These drawings are for a non-material amendment application to the previously approved design, reference '22/1164/FFFU'. Changes annotated on the drawings & are as follows:

Project Address
**24 Park Avenue, Camberley,
GU15 2NG**

Project Description
New Build

Sheet Title
Plans - Ground Level - Proposed GA

Sheet Ref. **MAP-C4813-103** Rev. **0**

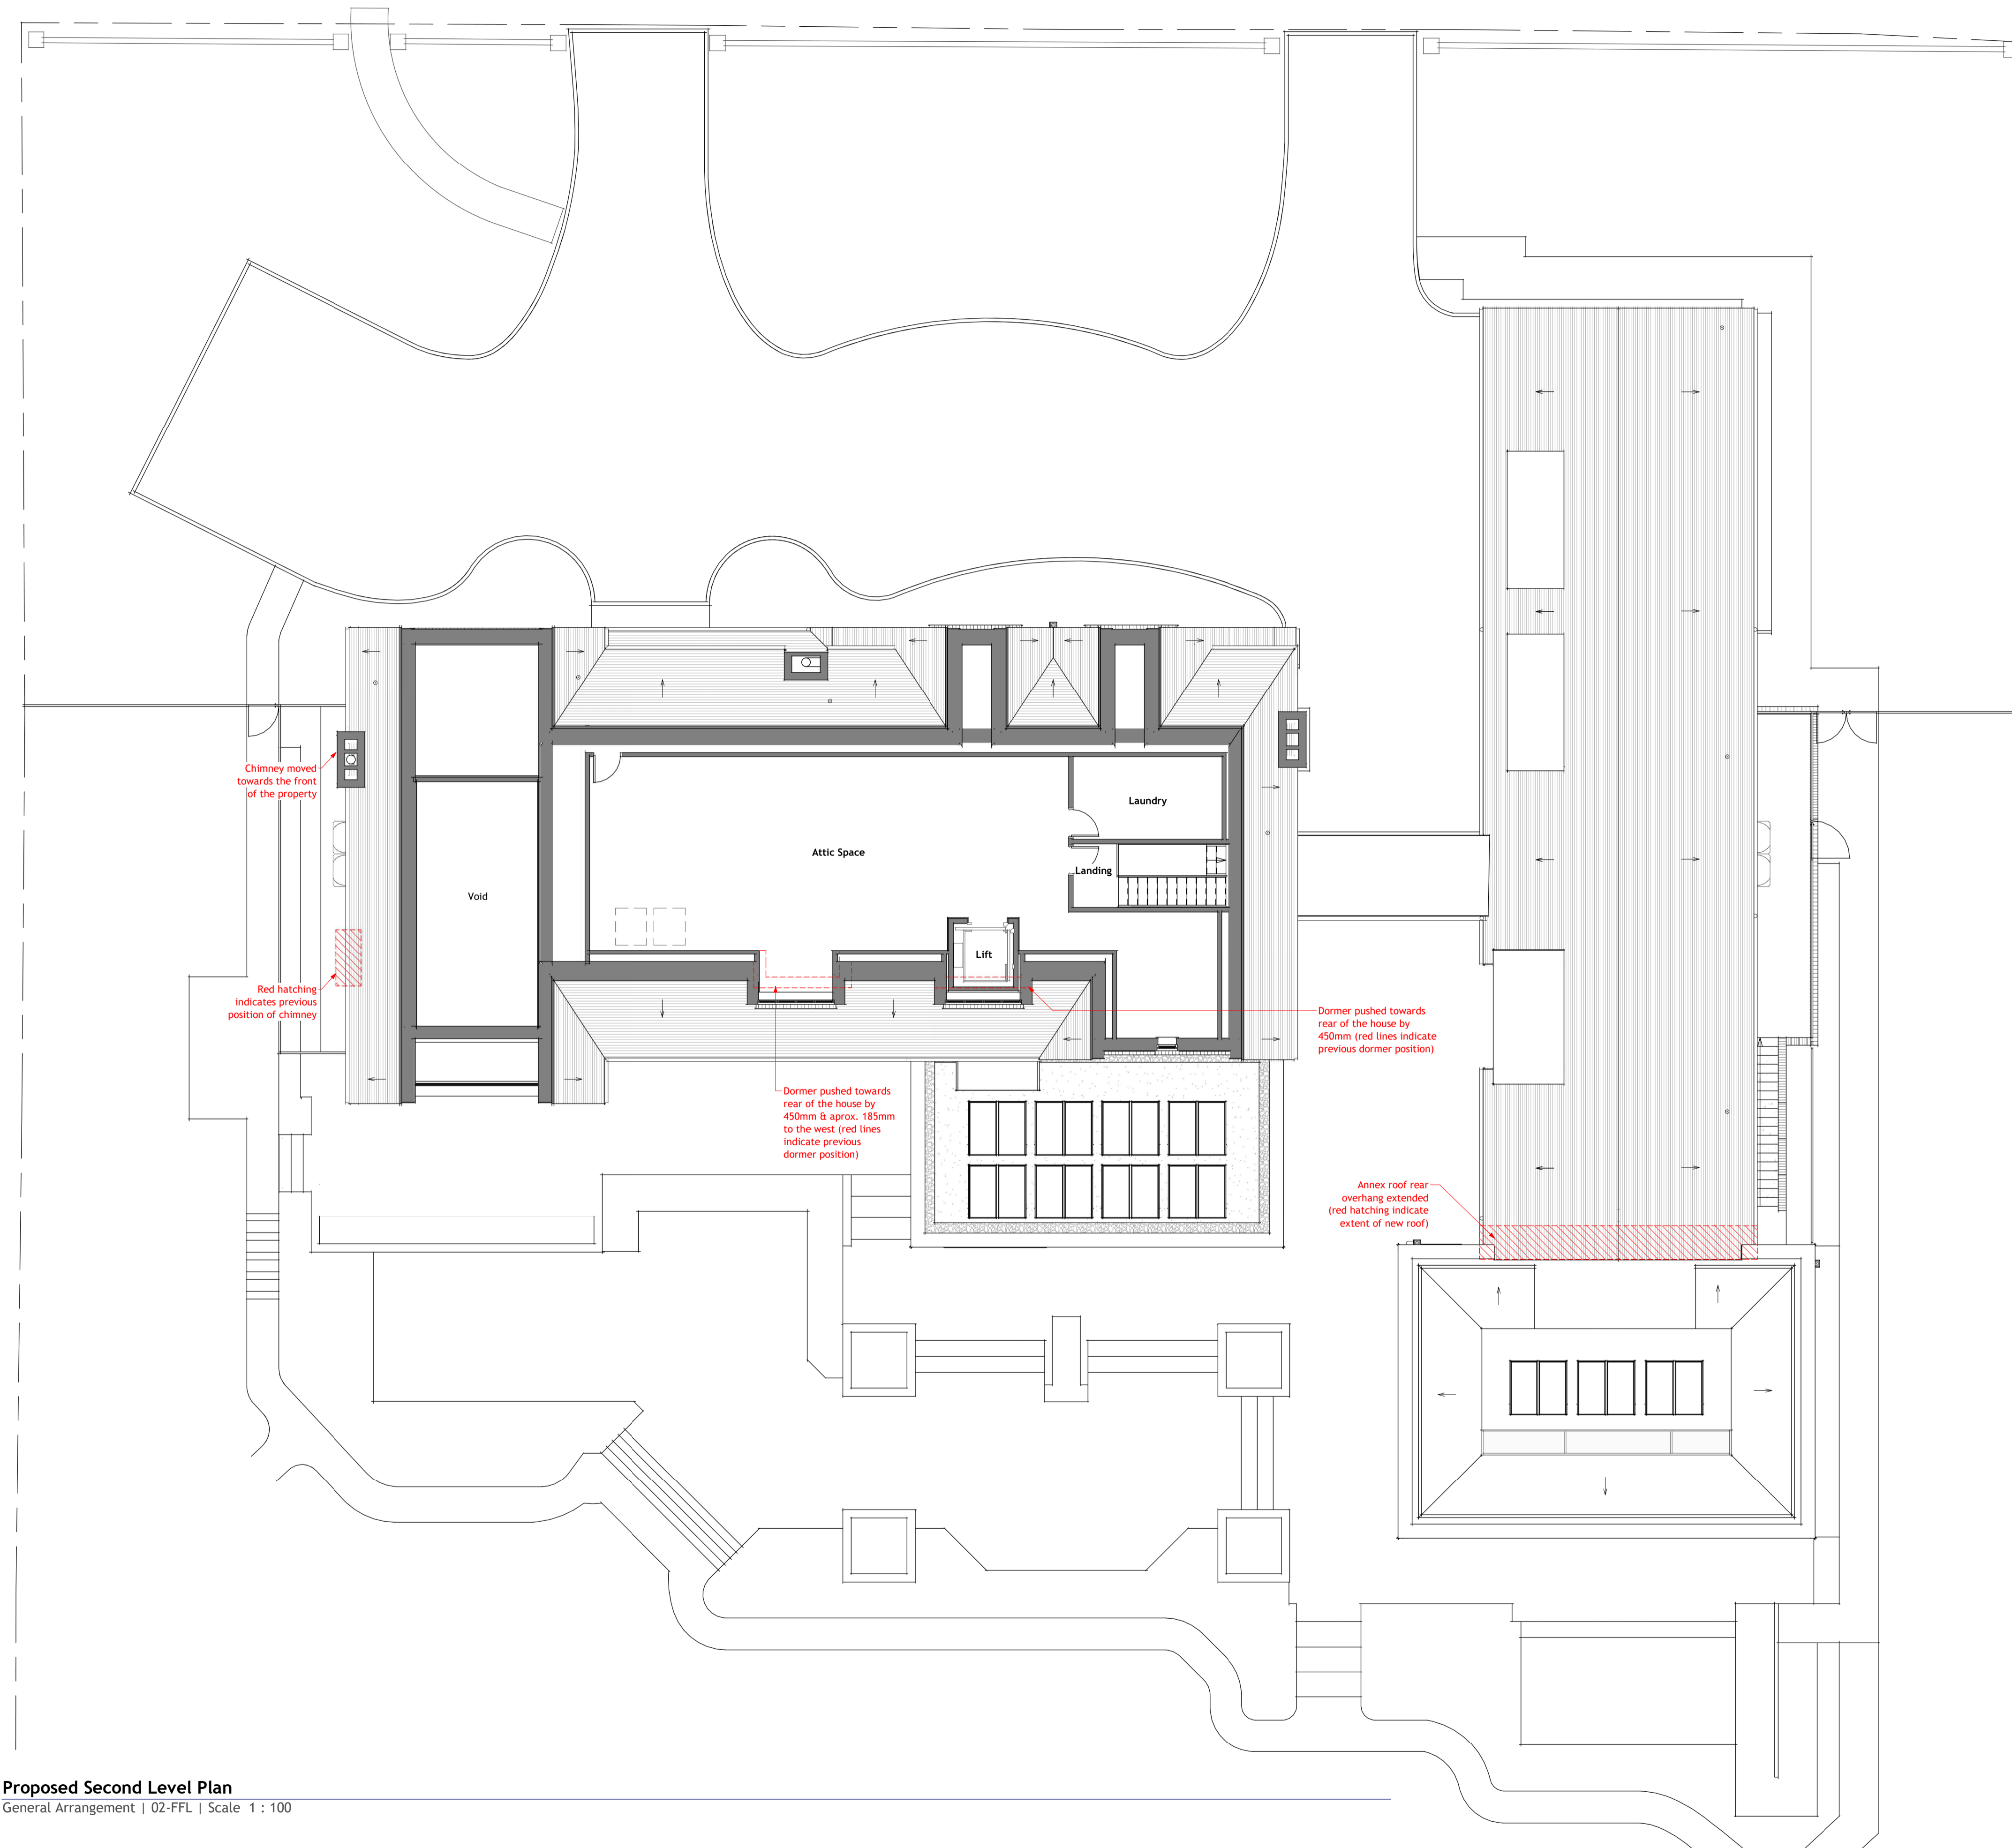
1. Windows size & position revised as shown on plans & elevations
2. Windows removed as shown on plans & elevations
3. New window in the east elevation of the house
4. West chimney moved towards the front of the house as shown on plans & elevations
5. Dormer windows position adjusted as shown on plans & elevations
6. House roof eaves raised & roof pitch reduced by 1No. degree as shown on elevations
7. 2No. rooflights added as shown on plans & elevations
8. Glass roof removed as shown on plans
9. Annex roof rear overhang extended as shown on plans & elevations
10. Annex East wall partly rendered behind fence as shown on elevations
11. Flat rooflight added as shown on plans
